Appeal Decision

Appeal Ref: APP/R4408/W/21/3287137 35 Huddersfield Road, Barnsley S75 1DN

- The appeal is made under section 78 of the Town and Country Planning Act 1990 against a refusal to grant planning permission.
 - The appeal is made by Mr Keith Blackburn against the decision of Barnsley Metropolitan Borough Council.
 - The application Ref 2021/0806, dated 4 June 2021, was refused by notice dated 23 August 2021.
 - The development proposed was originally described as conversion of existing basement to form 1 bed flat.
-

Drawing Title: As Proposed Plan and Elevation

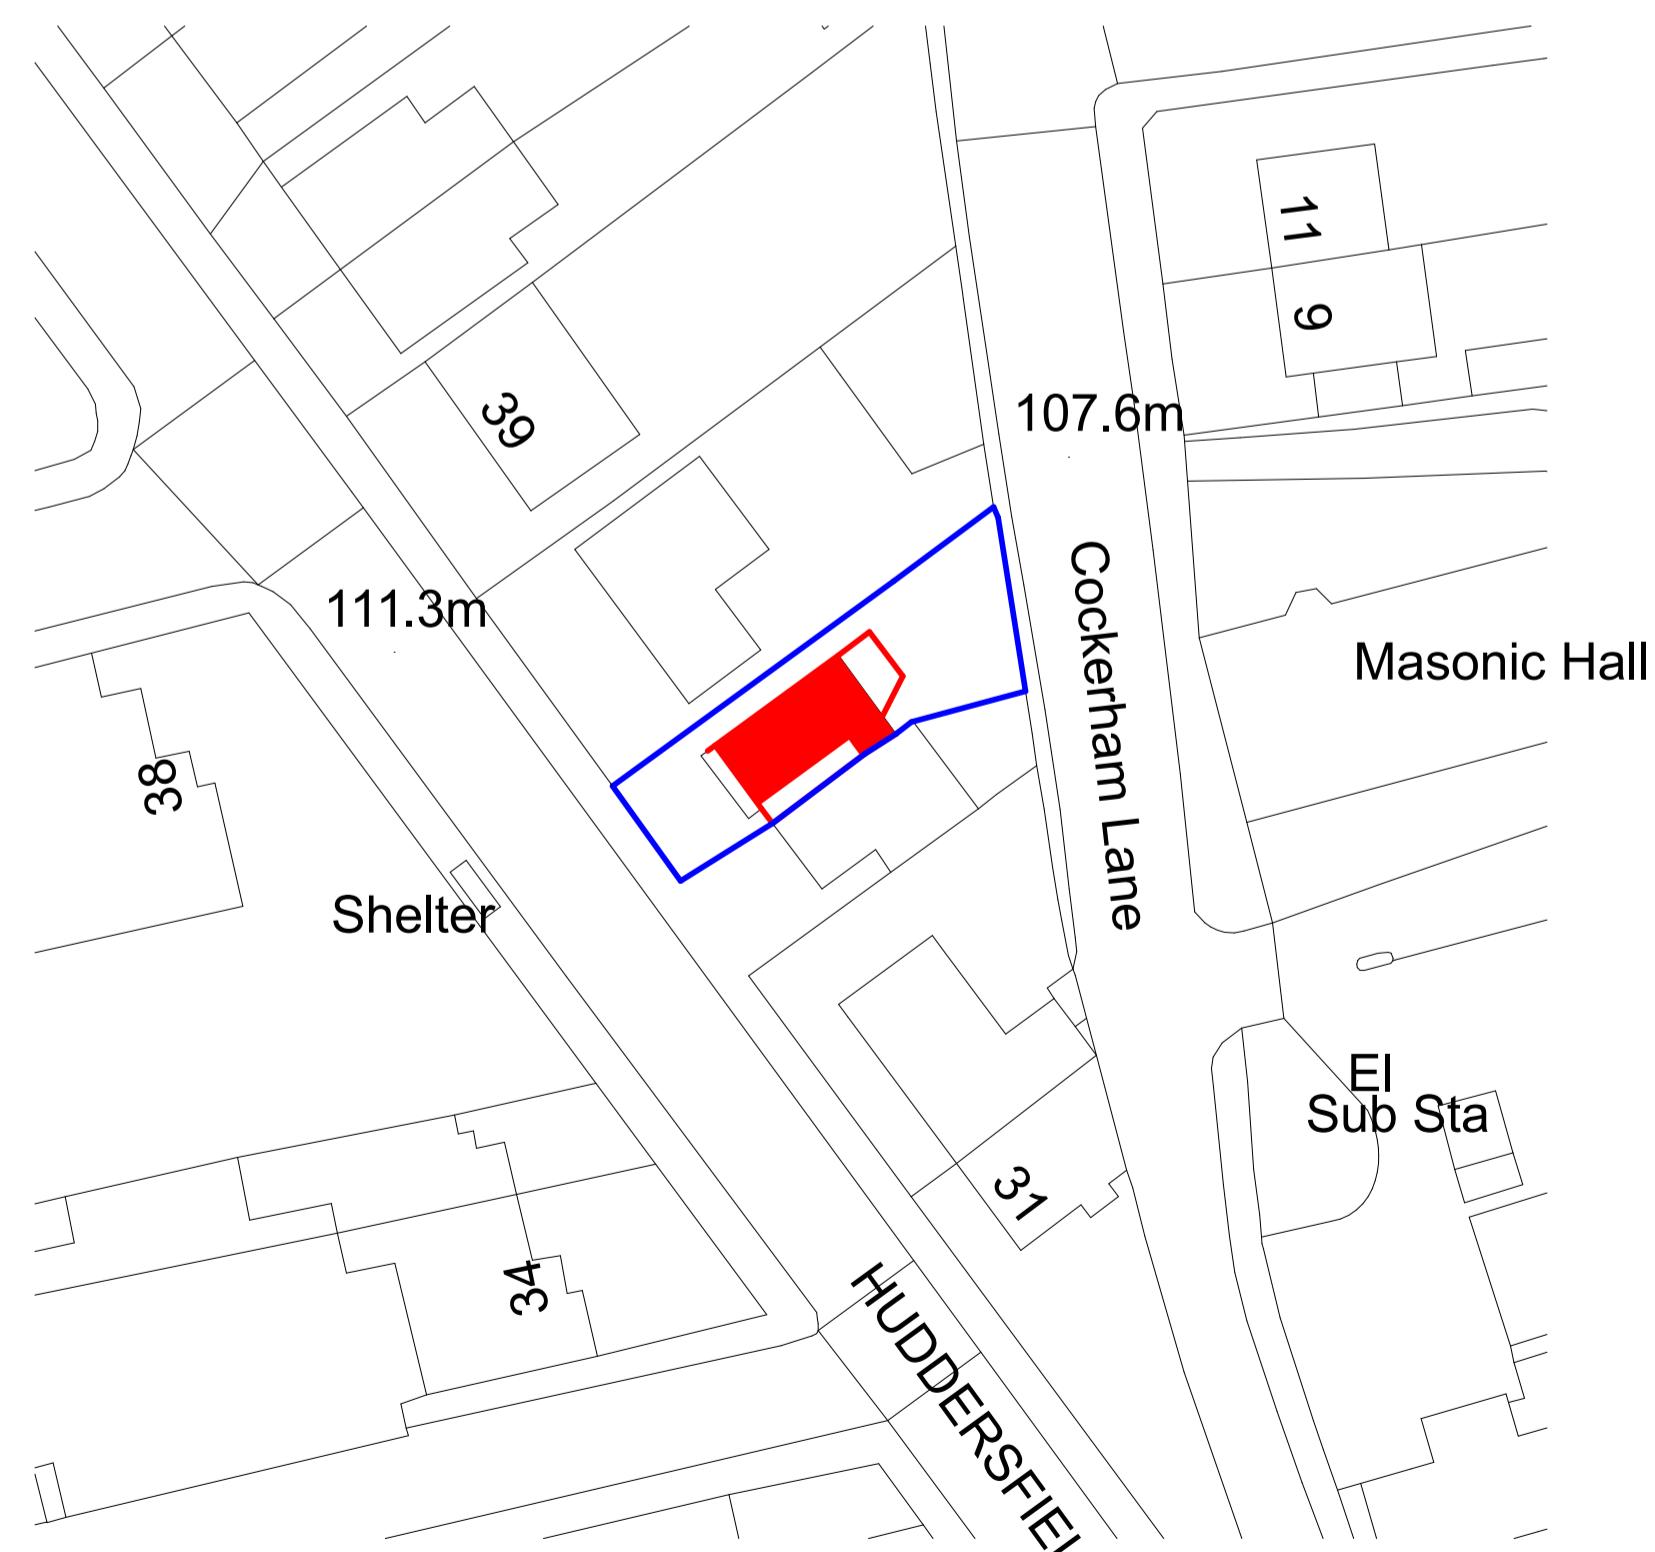
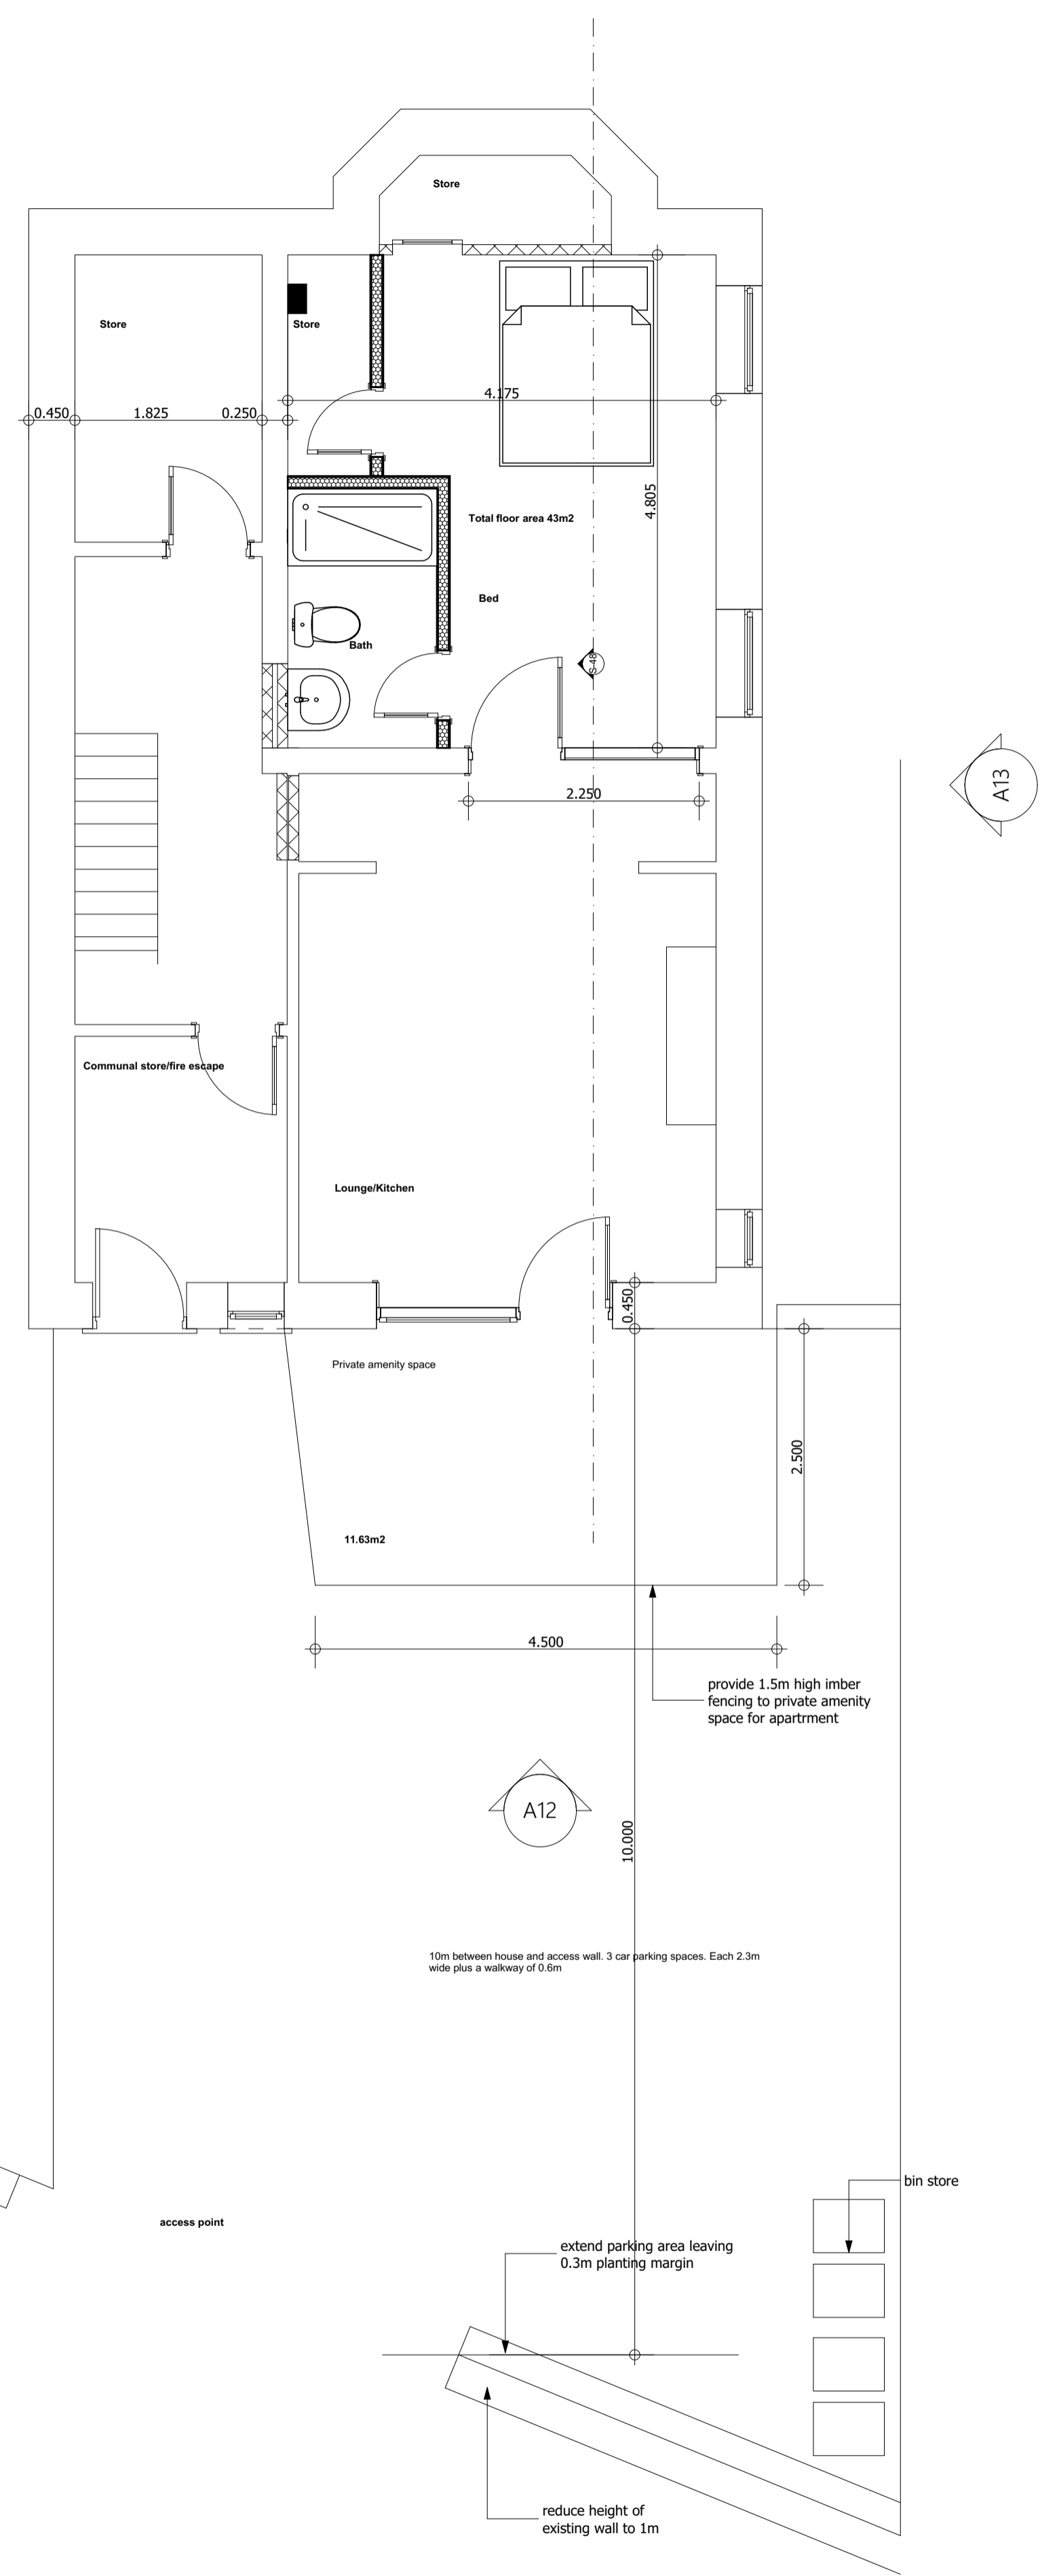
3. The appeal site relates to the basement of No 35 and is located within the CA. The proposed development involves reducing the width and height of the boundary wall adjacent to Cockerham Lane. The CA does not extend to the opposite side of Cockerham Lane.

5. The proposed boundary wall would appear at odds with the established character of the area and would result in the parking area being more conspicuous. In addition, the proposed private amenity space, and associated boundary treatment, would be visible. The fencing associated with the amenity space would appear out of keeping.

11. The proposed bedroom would be partially below ground level and would be served by two windows to the side elevation. The bedroom would have poor levels of light and outlook. This is because of the ground levels, distance to the neighbouring property and associated boundary wall and the orientation of the windows. I acknowledge that bedrooms are primarily used for sleeping but that does not justify the poor standard of accommodation.

12. The open plan kitchen/ living area would have a small window on the side elevation and glazing facing the proposed private amenity space. The proposed fencing associated with the private amenity space would be near the main window of the flat. Nonetheless, based on the evidence presented, I am satisfied that the open plan area would have adequate levels of outlook and light due to the extent of glazing and the proposed fence would help to ensure that the parking area is not overly prominent.

16. The proposed flat contains a bedroom, kitchen/ living area, bathroom and storage. Although the combined size of the rooms of the flat would be similar to that required in the SYRDG, the kitchen/ living area would fall short of the required 24sqm. Given that the bedroom has poor levels of outlook and light, it is likely that future occupiers would spend a large amount of time in the open plan area. As a consequence of particularly the size of the proposed open plan area, the scheme would result in a poor standard of accommodation as the flat would feel cramped and would not provide adequate space for occupiers' day-to-day needs.
